Our Ref: EN020016

Date: 6 July 2015

Application by Western Power Distribution (South Wales) plc for an Order Granting Development Consent for the Brechfa Forest Connection

Procedural decision following issue of acceptance decision

Title
 WESTERN POWER DISTRIBUTION
 (BRECHFA FOREST CONNECTION) ORDER
 LAND PLANS
 (REGULATION 5(2)(i)(ii))
 SECTION C

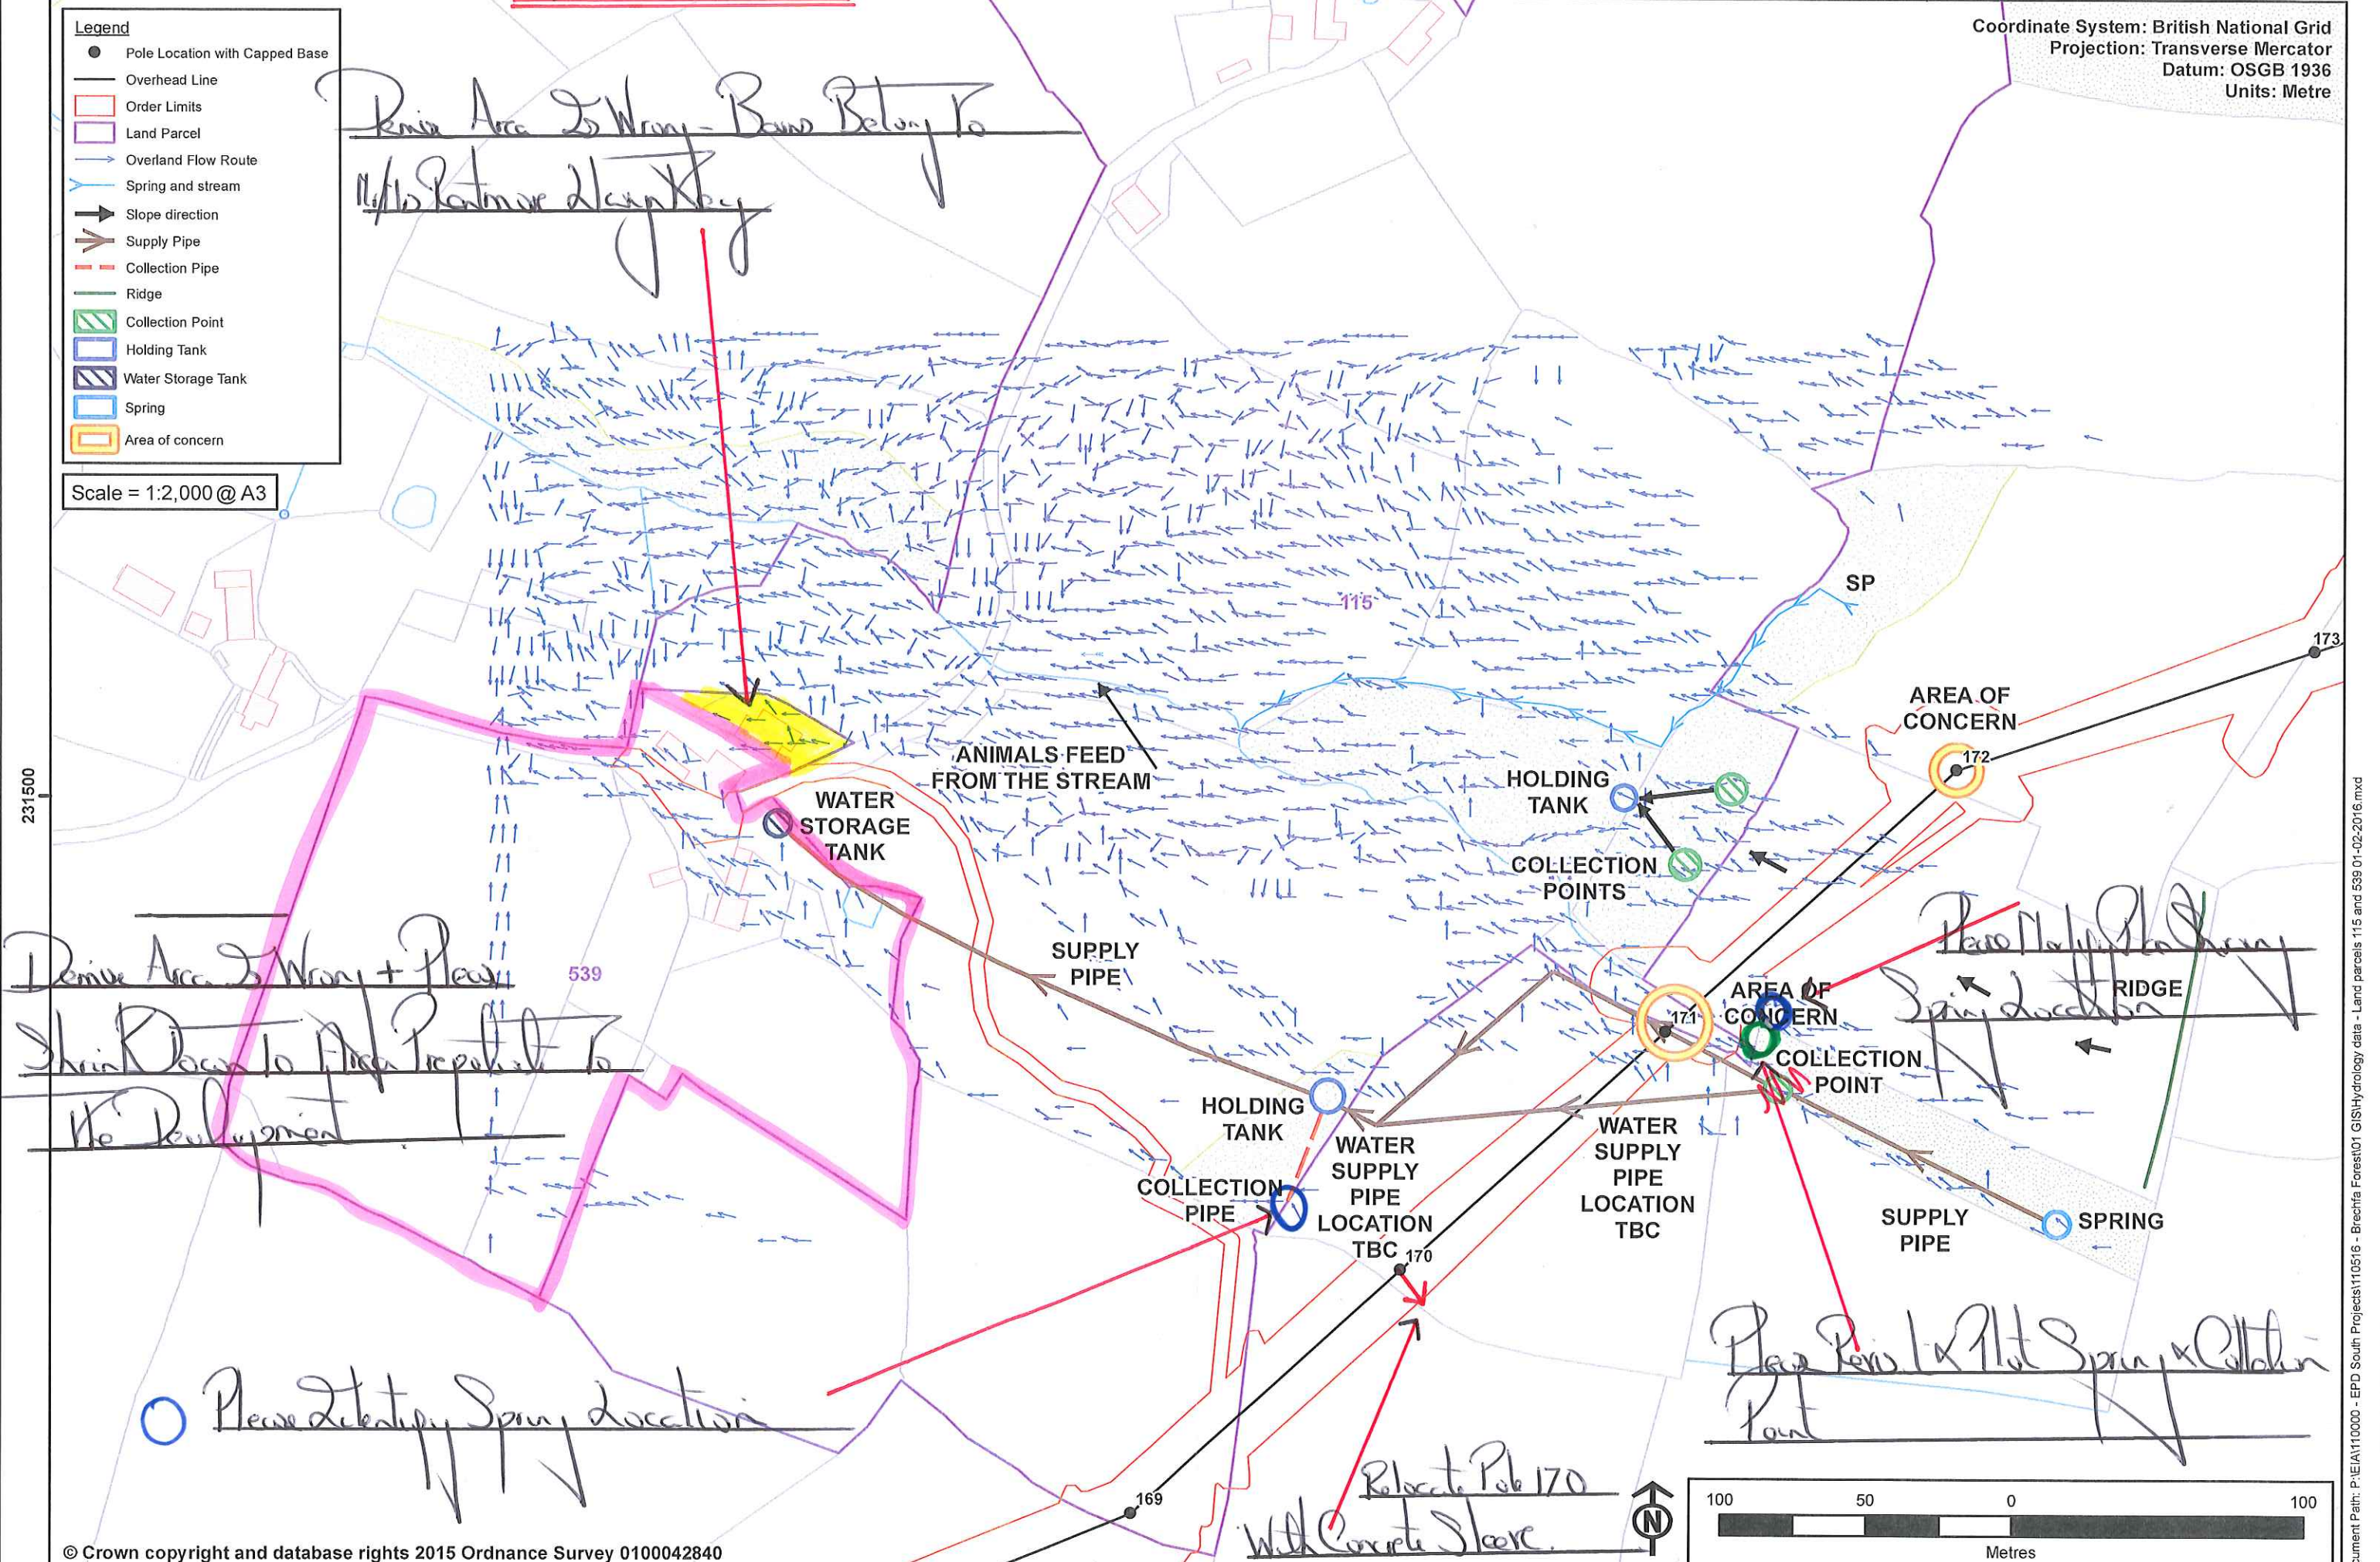
The Planning Inspectorate has recorded in the acceptance checklist (Box 3.3(i)) several plots in the Land plans (Doc 2.2) which are not shown sufficiently clearly, are incorrectly labelled or which differ from their description in the Book of Reference (Doc 4.3). These discrepancies will need to be rectified so that affected persons and the ExA can be confident of the scope of Compulsory Acquisition applied for. Updated documents are required to rectify these issues.
